Householder Application for Planning Permission for works or extension to a dwelling. Town and Country Planning Act 1990

PROPOSED DORMER WINDOWS TO THE FRONT,
TOGETHER WITH A SIDE EXTENSION TO THE
BUNGALOW - see attached e-mail

RE: Proposed dormer windows to the front, together with a side extension to the bungalow
AT: 26 Whalley Road, Langho

Roofspace plan

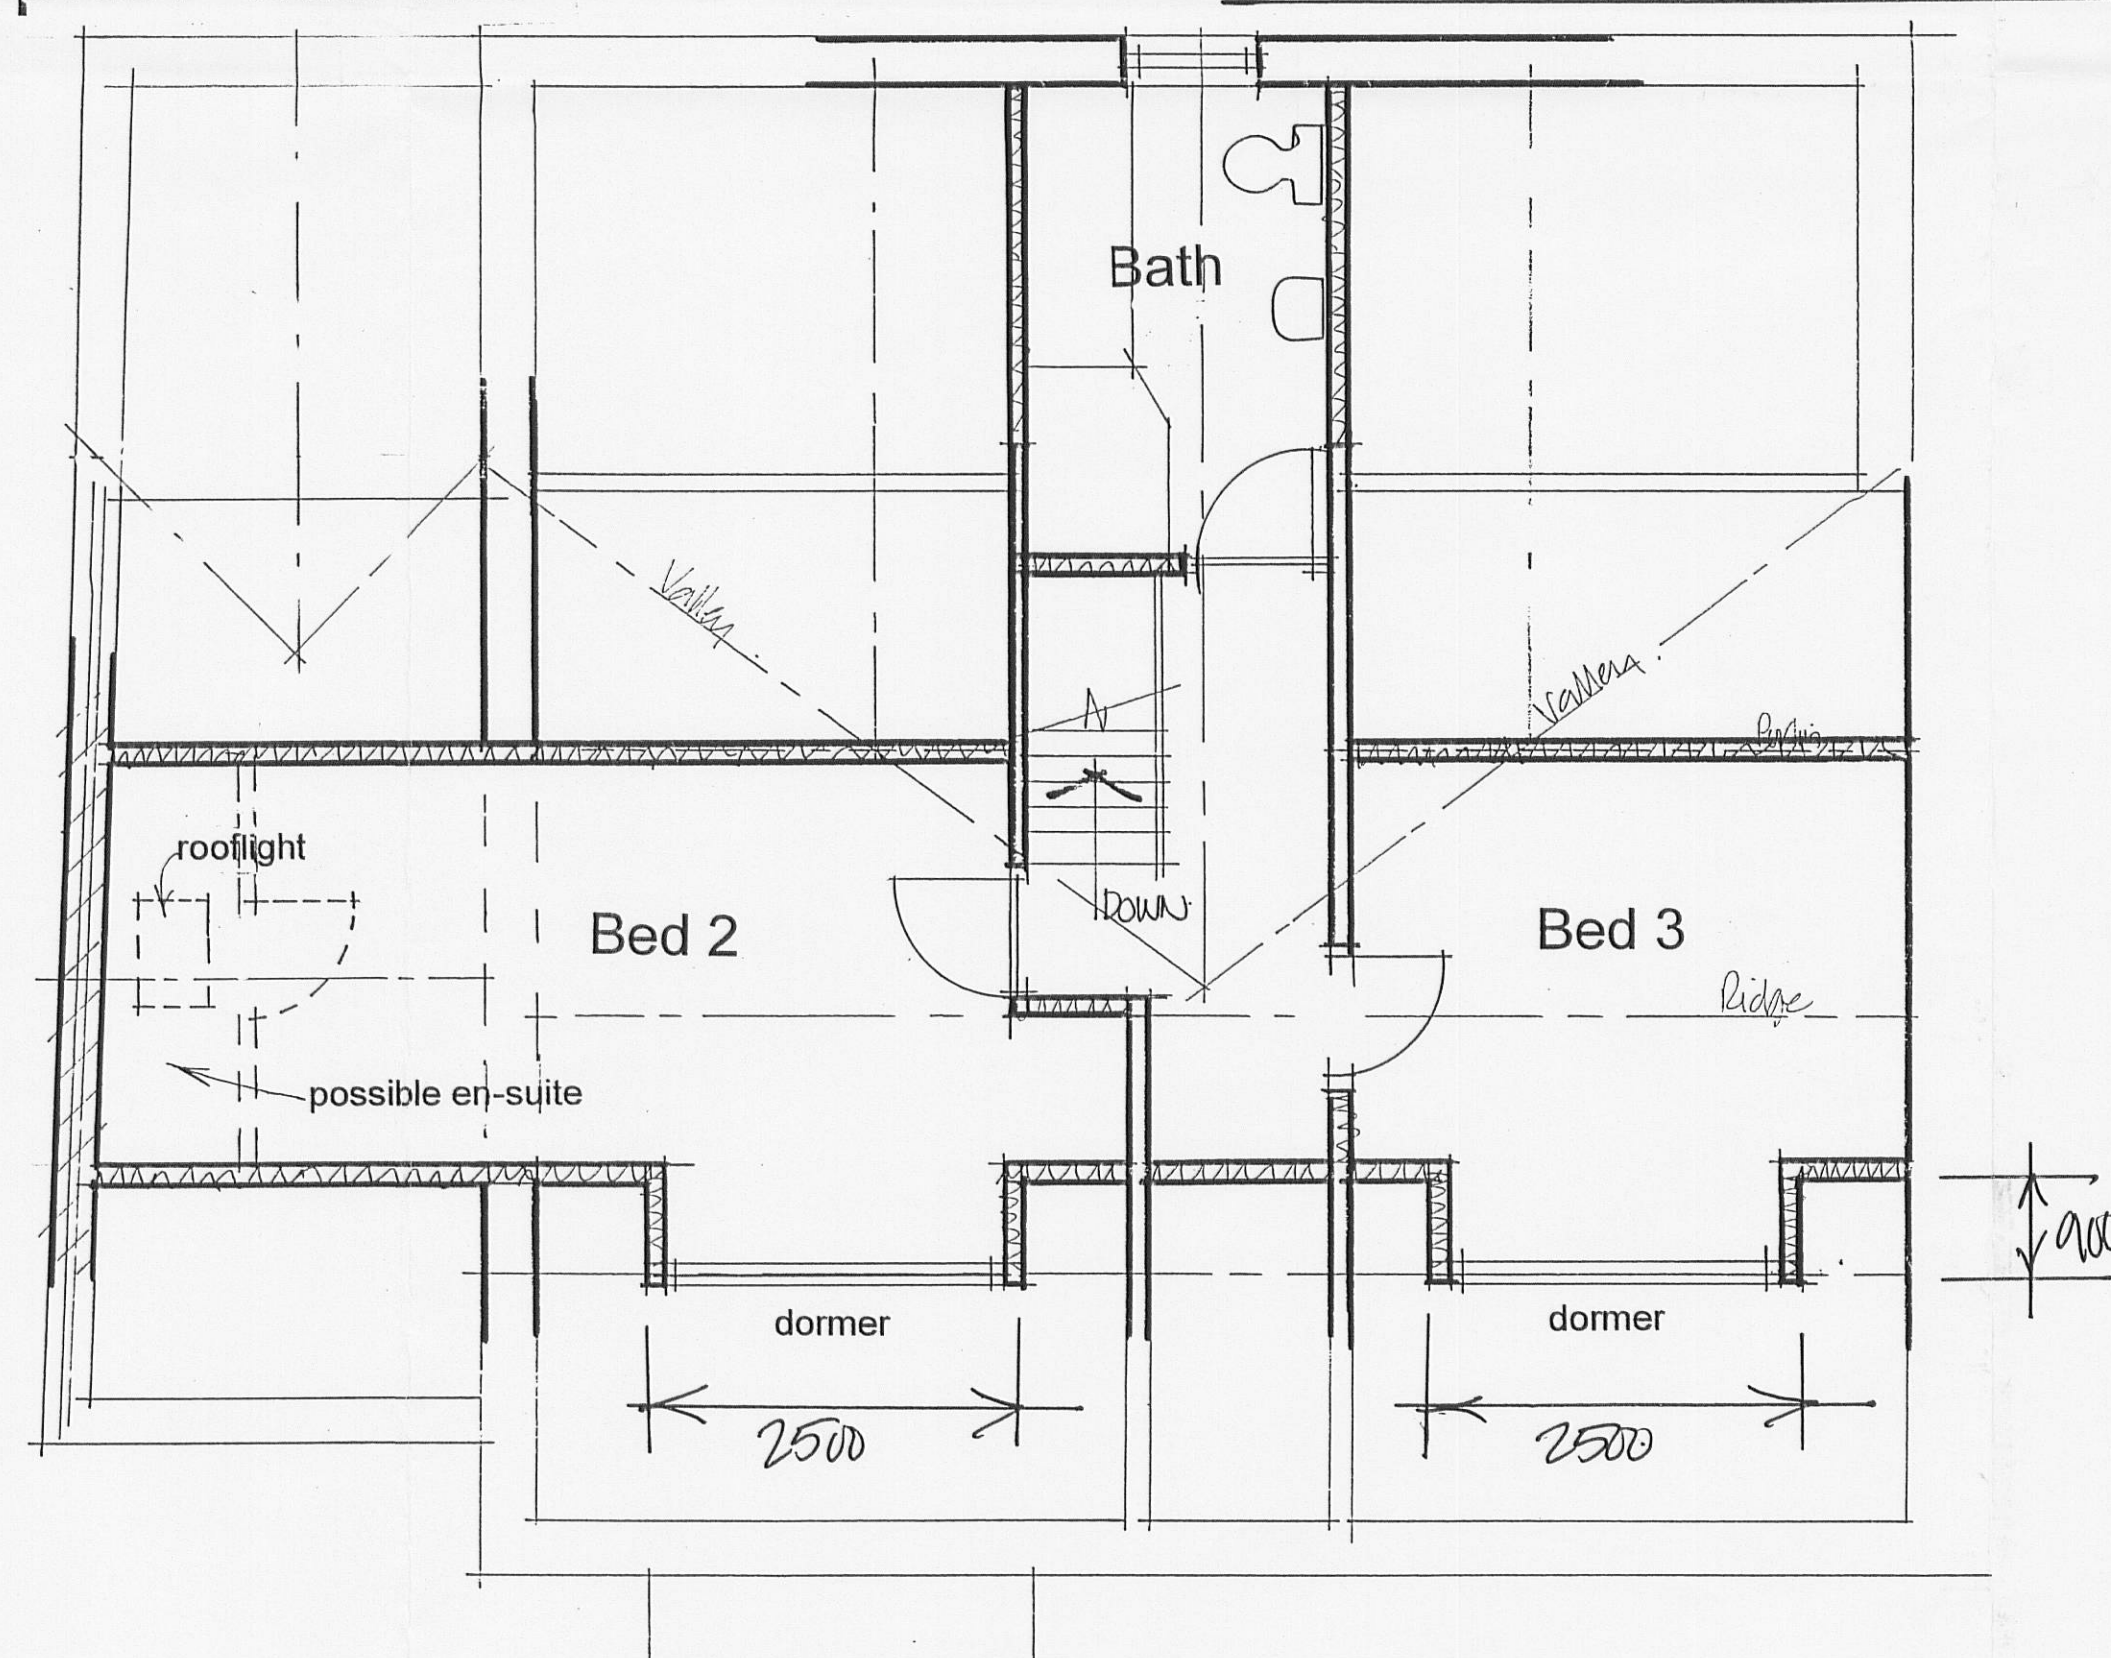
- All proposals need to be annotated with dimensions but only the height of the proposed extension is on the drawings. Please can you also add the overall external length and width of the extension. In relation to the proposed dormers please can you add the overall external height, width and projection.
- For clarity please can you show on the existing drawings that the garage will be demolished - either a label or highlighting/hatching will be fine. Also, please can you confirm that you are happy for 'Demolition of existing garage' to be added to the description.
